2 November 2018

## Appendix A

### Record and Response to Submissions

Extracts from Government agency and authority submissions and submissions from the general public received in relation to SSD 18\_9347, and a response to each of these matters, has been outlined in the table below.

Stage 1 amending DA envelope with City of Sydney suggested 8x8m notches

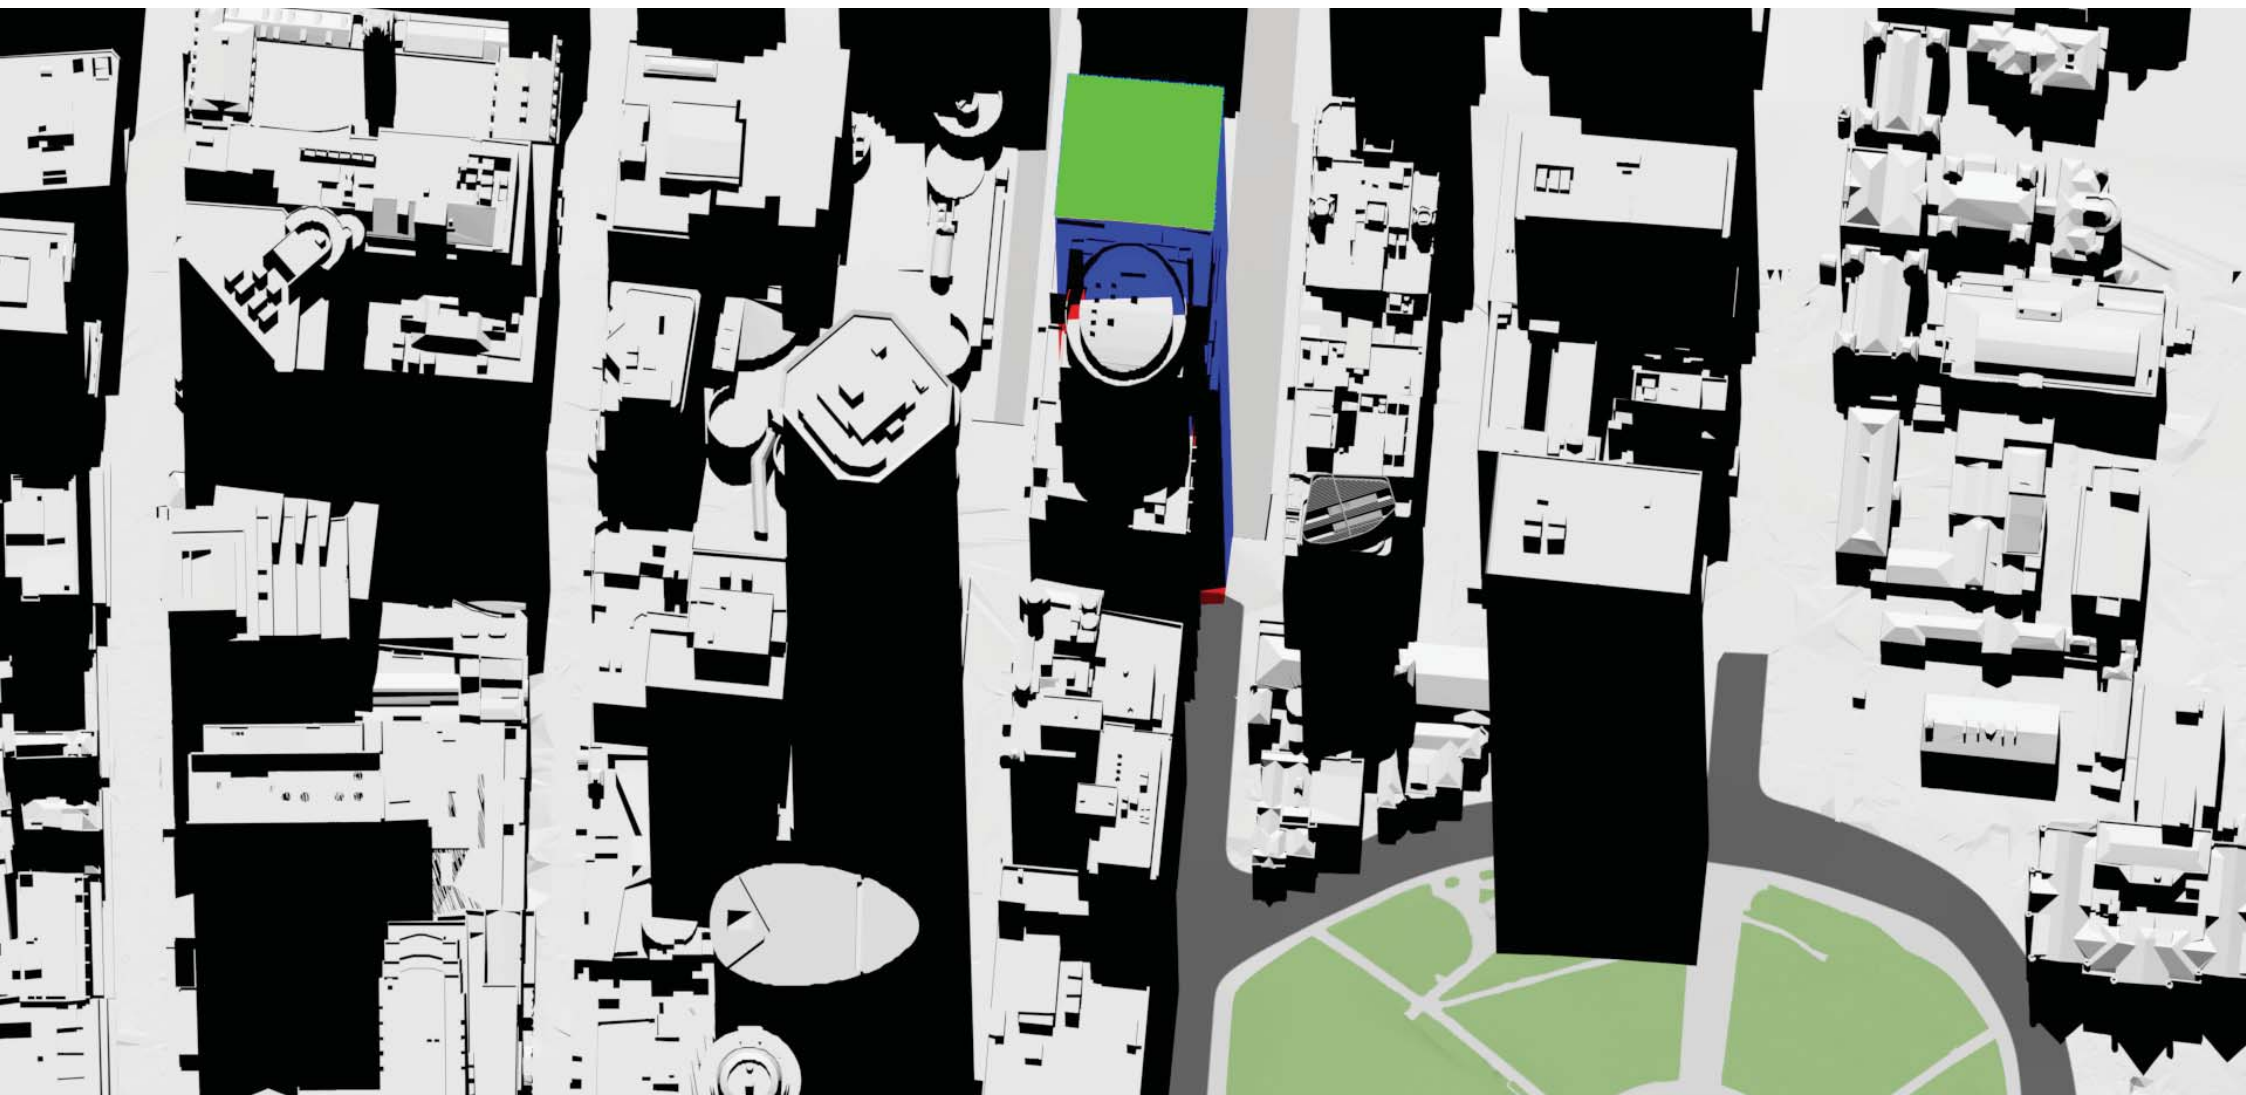
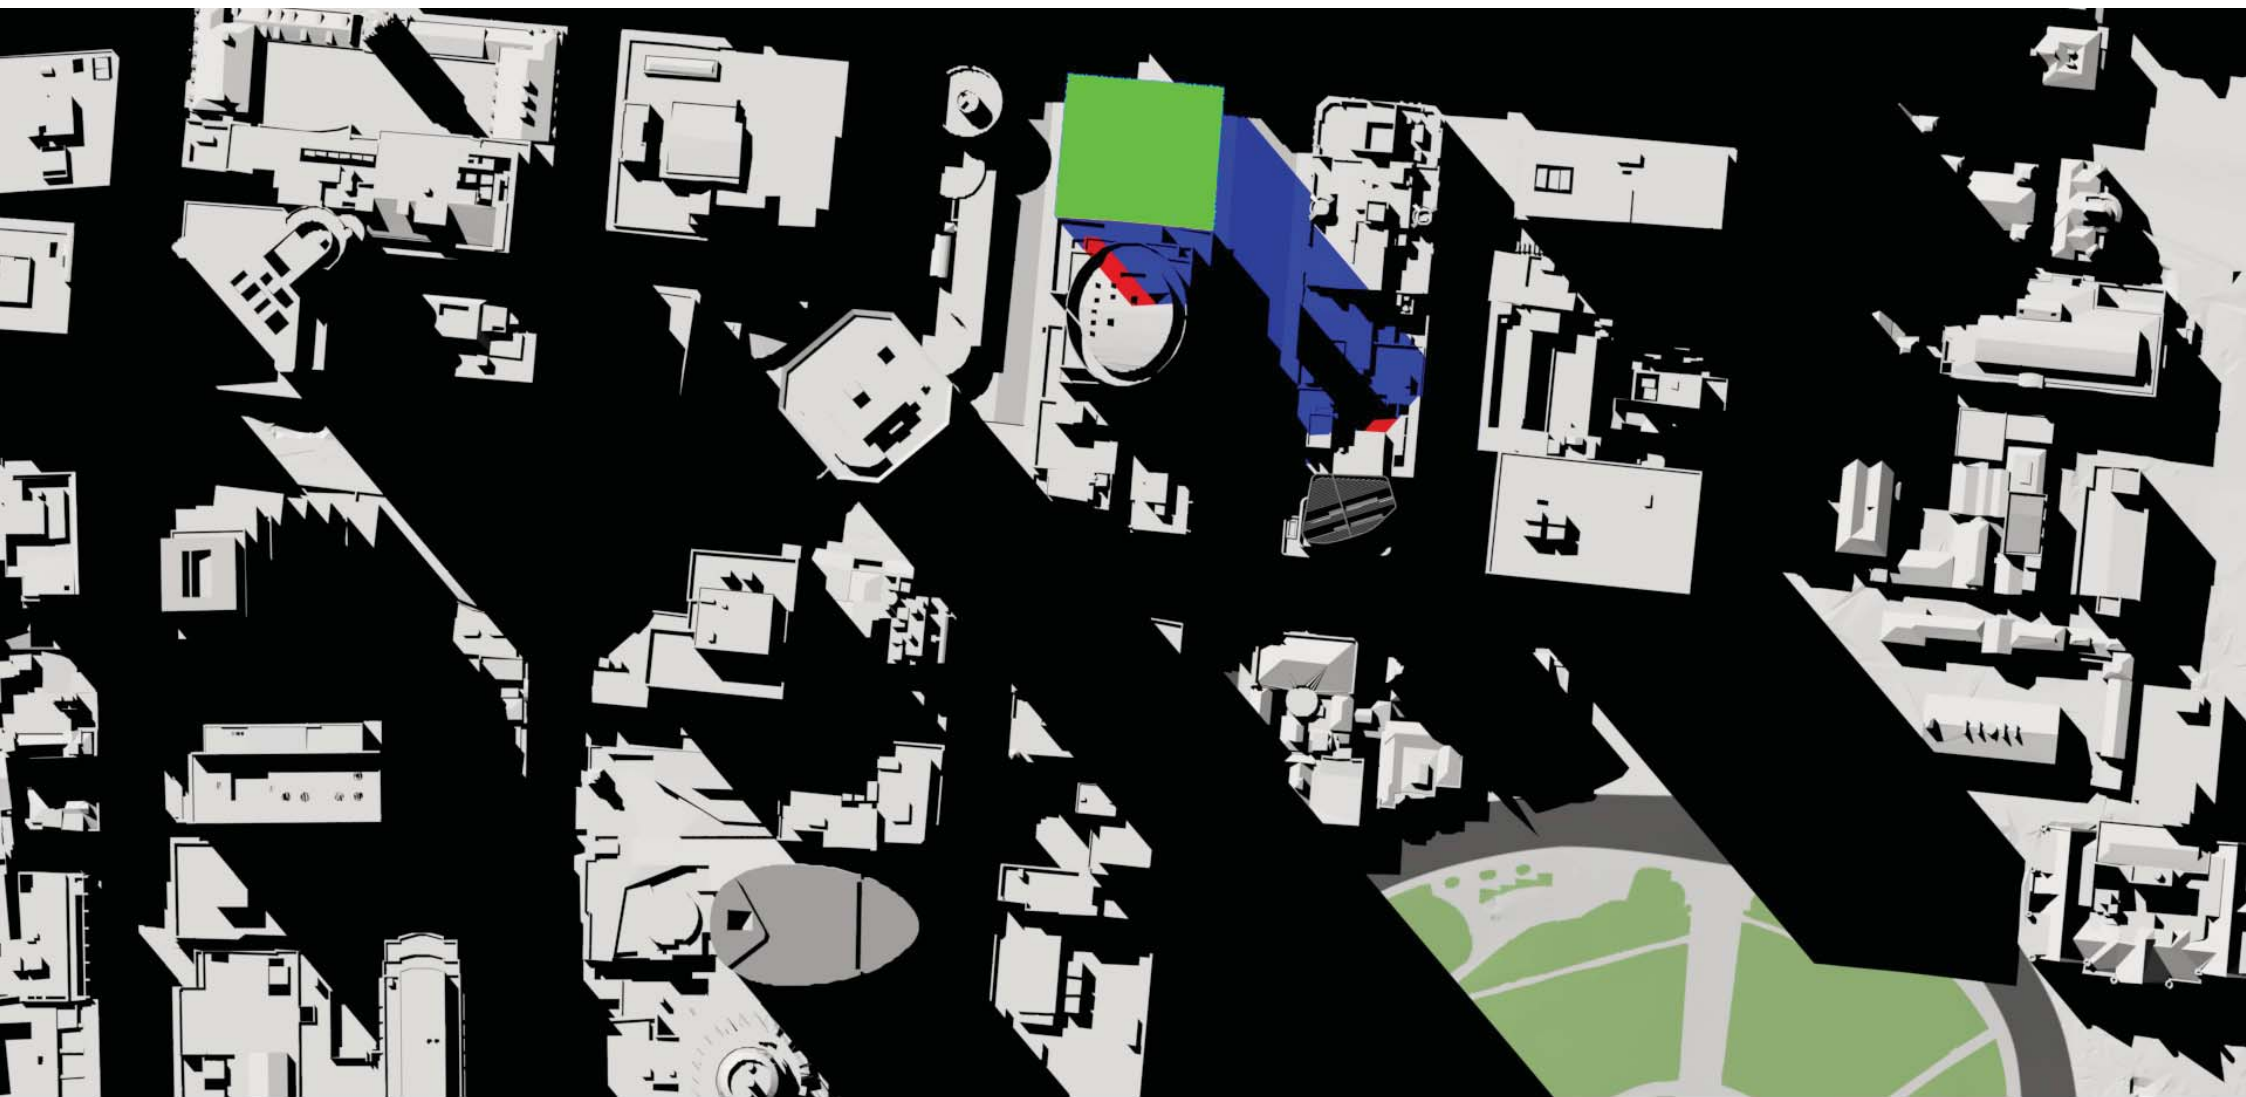
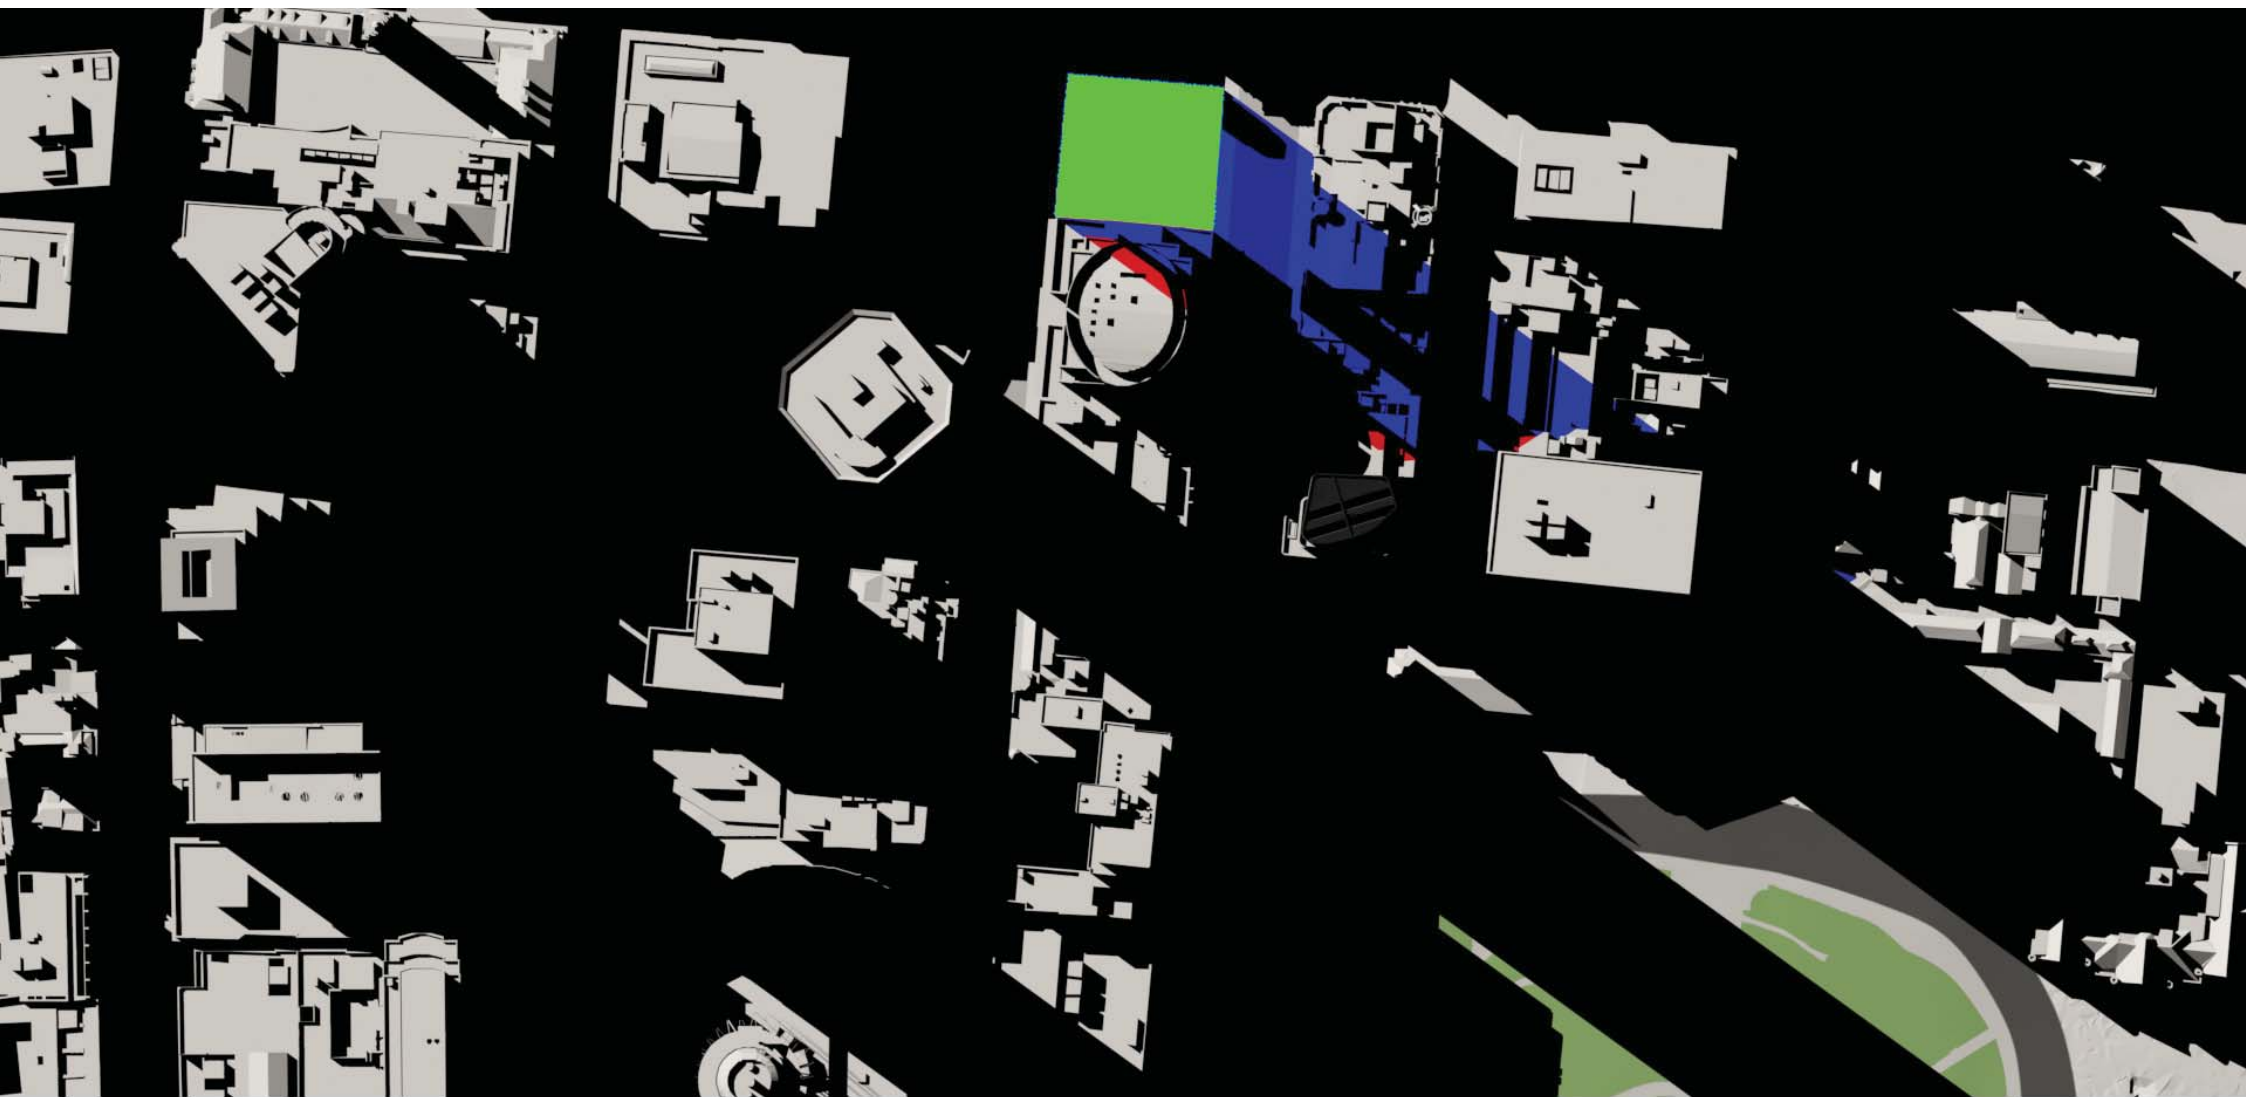
<p>In lieu of incorporating the recommendations regarding street frontage conditions along Elizabeth and Castlereagh Streets as part of the existing concept approval (SSD 8351), it is recommended that in amending the concept envelope and increasing the building mass of the south tower, building returns be incorporated in the southern corners of the envelope as a transition to the adjoining development to the south above the podium height. This would in part assist in achieving the outcome of the Independent Planning Commission's advice of reinforcing the importance of the urban character and integrity of Martin Place and the associated city blocks. A return of 8m x 8m is recommended for each corner for the building above a nominal 45m podium height.</p>	<p>The returns suggested in the City's submission would undermine the creation of a successful transition to the adjoining development to the south. The returns suggested would also undermine the distinct threshold condition being created by the proposed development that reinforces the uniqueness and legibility of Martin Place within the urban fabric of the city. The introduction of recesses in the South Tower has been previously considered and reviewed by both the Sydney Metro and site-specific Design Review Panel, and was not supported as the desired or ultimate outcome for the South Site.</p> <p>The introduction of recesses is not an appropriate design response for the following reasons (as detailed further in the covering RtS report and supporting consultants' reports):</p> <ul style="list-style-type: none"> <li>• The amended building envelope for the South Tower is consistent with the approved relationship between the South Site and the southern boundary. A zero setback to the southern boundary was approved under the Concept Proposal (SSD 17_8351) and formalised in the endorsed Consolidated Design Guidelines. The treatment of the building envelope to existing and future developments to the south was supported and remains unchanged in the Stage 1 Amending DA.</li> <li>• The introduction of 8m by 8m recesses at a height of 45m therefore does not relate to the existing development to the south, creating a potentially awkward built form relationship between the proposal and the adjoining and adjacent development. It creates a new setback and podium height that is not echoed in the existing development to the south, and limits the flexibility to redevelop land to the south with regards to podium height and pressures of the Sun Access Plane (SAP). This is detailed in the supplementary response prepared by Tzannes and included at Appendix B of the RtS.</li> <li>• The proposed zero setback to the southern boundary defines the edge of this threshold, and is important for reinforcing the legibility of Martin Place in the urban fabric. Including recesses in the façade would undermine this threshold condition and therefore undermine the ability of the development to provide a clear sense of arrival to Martin Place. This would have the effect of reducing Martin Place's differential or 'specialness' when moving through the city, and as such would not achieve the Council's desire to reinforce the 'importance' and 'integrity of Martin Place'.</li> <li>• The introduction of 8m x 8m recesses above the podium would reduce the area of usable floor space to 972m<sup>2</sup> of Net Lettable Area (NLA). This reduced floorplate impacts the ability of the South Tower to attract and accommodate large multi-floor occupants and premium global businesses, which in turn undermines the ability of the South Site to contribute to the long-term viability and competitiveness of the Sydney CBD.</li> </ul>

Extract	Response
	<ul style="list-style-type: none"> <li>Introducing recesses into the proposed South Tower building envelope will not result in any meaningful environmental benefits. This has been detailed in the technical studies that accompanied the EIS and approved Concept Proposal, and the RTS, which conclude there would be no recognisable improvement to wind conditions, overshadowing or views.</li> <li>The introduction of recesses to the building envelope would require a range of associated changes to the building and integrated station, as they impact on the structure of the building.</li> </ul>
<p>The Wind Environment Study prepared by CPP for the proposal indicates that locations around the site (17-19, 23-26) would experience increased wind speeds as compared to the existing concept envelope. As noted in previous submissions to the existing concept envelope, design options that retain the current comfort ratings (including the consideration of weather protection) should be considered.</p>	<p>The building envelope considered under the Stage 1 Amending DA does not preclude achieving a good pedestrian wind environment, and meeting the commitments of the Consolidated Urban Design Guidelines (as proposed to be amended) to create pedestrian standing environments at station entrances.</p> <ul style="list-style-type: none"> <li>All areas that were assessed remain suitable for their intended use in this section of the city, and as such the change to the comfort rating does not adversely impact the intended function of these spaces.</li> <li>The measured threshold wind speed is close to the boundary between two comfort categories in both locations, and as such even though the comfort rating has changed, the relative magnitude of the change is minor. CPP confirms that there is negligible difference in wind conditions between the approved and amended configuration.</li> <li>The results relate to the approved and amended maximum building envelopes and not the detailed design of the South Tower. Wind conditions are improved in the detailed design of the South Tower, as outlined in the Pedestrian Wind Environment Study accompanying the Stage 2 DA for the South Site (SSD 18_9326). This detailed analysis accompanying the Stage 2 DA confirms that the surrounding pedestrian environment complies with the relevant safety criteria, and that pedestrian comfort has been improved at every location when compared to the building envelope (other than one location, which still meets the desired 'pedestrian standing' criterion). Accordingly, the detailed design of the South Tower already largely achieves the objective of retaining or improving comfort ratings.</li> <li>The amended South Tower building envelope is also capable of achieving a 'pedestrian standing' criteria at the station entrance, which is identified in both the approved and amended Consolidated Design Guidelines as being a key aspiration for the development.</li> </ul>
